City of Albuquerque Stormwater Construction Site Inspection Report

General Information					
ESC File No.	L15E051A	Project Name:	Raising Cane's		
NPDES Id. No.	NMR1005S1	Location:	1401 Gibson Blvd SE		
1/31/2024	Owner -		Contractor		
Operator	Raising Cane's Restaurants, LLC		Embree Construction Group Inc.		
Contact name & title	Robert Montgomery		Shane Craven		
e-mail	rmontgomery@raisingcanes.com		scraven@embreegroup.com		
Contact Phone #	972-769-3364		512-630-9651		
COA Inspector	Doug Hughes		Start/End Time:	3:30PM	
Construction Phase:	Framing & Utilities				
Type of Inspection:	Regular	Storm Event	Past Storm Event >0.25"	311/Complaint	Follow Up
Weather at time of inspection?		Cloudy	Temperature: ~		45
Estimated date of last storm 0.25" or greater		1/4/2024

C3.1

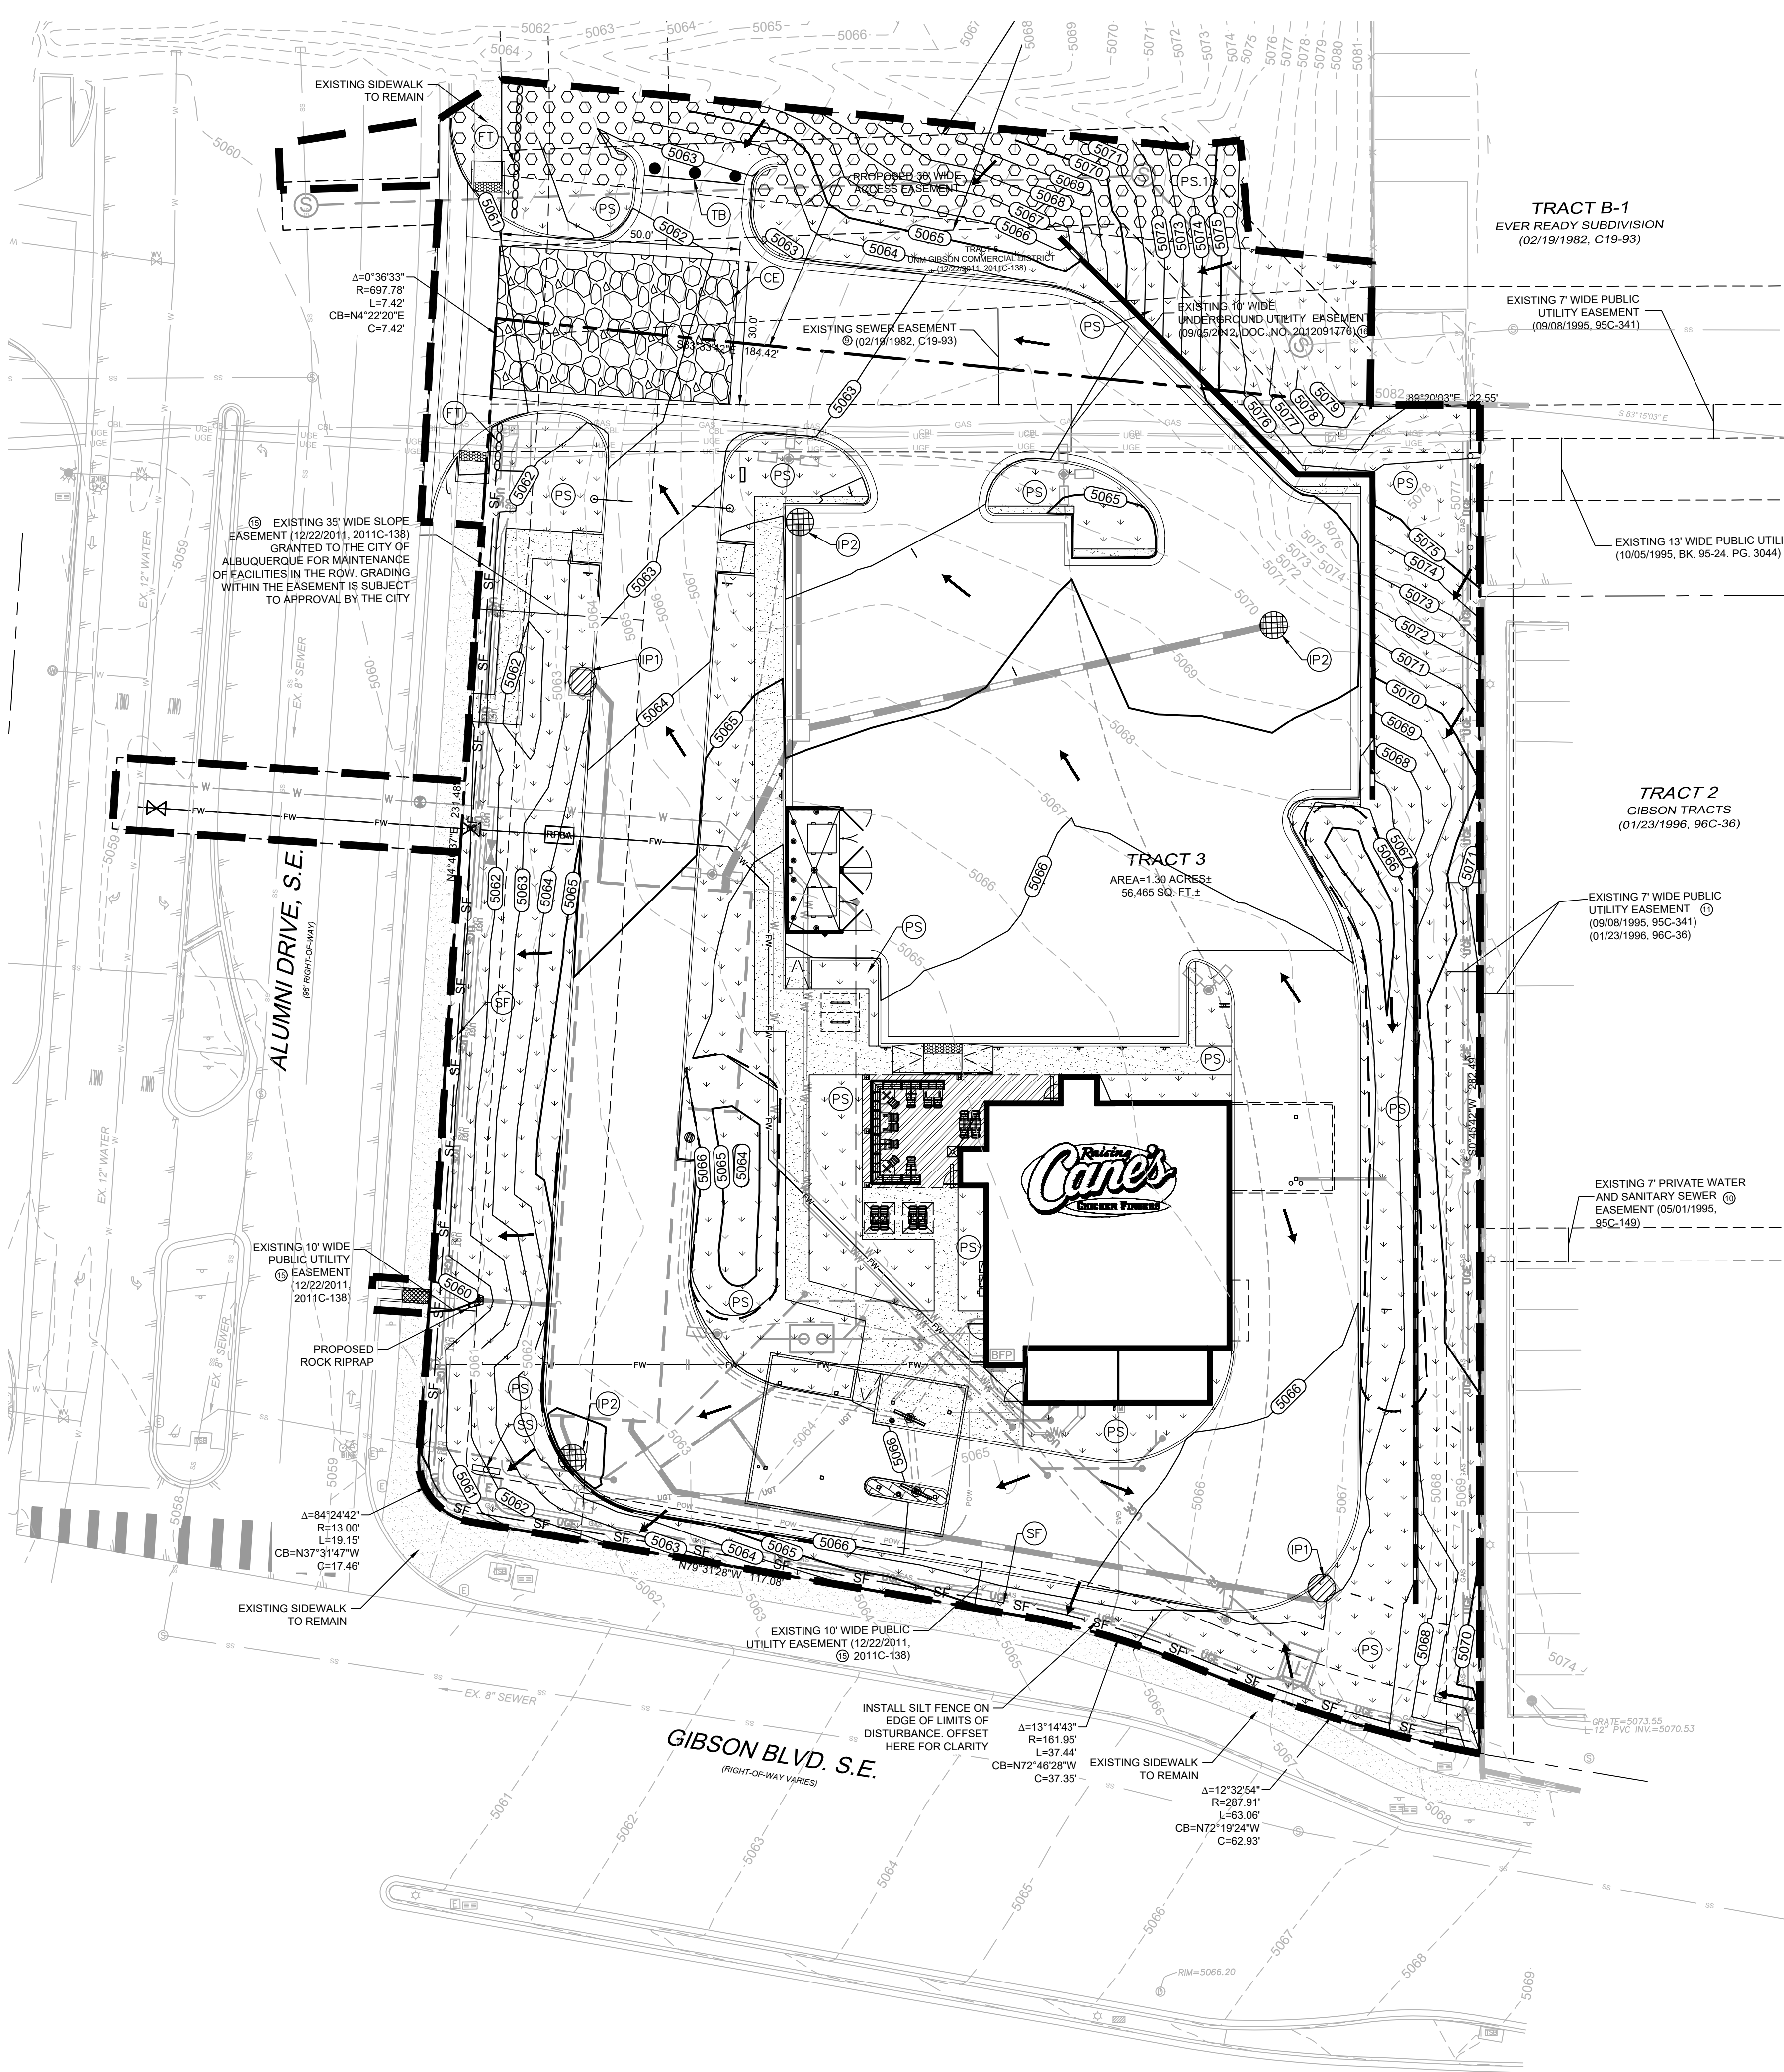
4	SWPPP - The SWPPP was not up-to-date in violation of CGP 7.3. a. The SWPPP Map didn't identify the missing silt fence on the west side of the site. b. There weren't any corrective action reports or logs documenting any dates when the silt fence went missing from the west side of the site in violation of CGP 5.2.4. Reports failed to document why it was infeasible to complete the installation or repair within the required 7-day corrective action deadline, and your schedule for installing the stormwater controls and making them operational as soon as feasible after the 7-day timeframe was also missing, all in violation of CGP 5.2.1.c. Required Mitigation: The SWPPP, including Self Inspection Reports and Corrective Action Reports, must be kept up-to-date throughout coverage per CGP 7.1, and it must be available on-site per CGP 7.3. During dry utility construction, alternative perimeter controls must be designed by the stormwater team member responsible for design of the stormwater controls per CGP 6.1.a and 9.6.1.c.iii, shown on the SWPPP map, and reported in a Corrective Action report signed by the owner/operator.

5	Sediment has been washed into the street, as evidenced by the erosion marks in the dried mud in the gutter and sidewalk along Alumni Dr. and the deposited sediment in the low spot at the south end of Alumni Dr. This is also indicative of a sediment-laden stormwater discharge most likely due to the lack of perimeter controls on the west side of the site. Required Mitigation: Where sediment has been tracked-out from your site onto paved roads, sidewalks, or other paved areas outside of your site, remove the deposited sediment by the end of the same business day in which the track-out occurs or by the end of the next business day if track-out occurs on a non-business day. Remove the track-out by sweeping, shoveling, or vacuuming these surfaces or by using other similarly effective means of sediment removal. You are prohibited from hosing or sweeping tracked-out sediment into any constructed or natural site drainage feature, storm drain inlet, or receiving water.
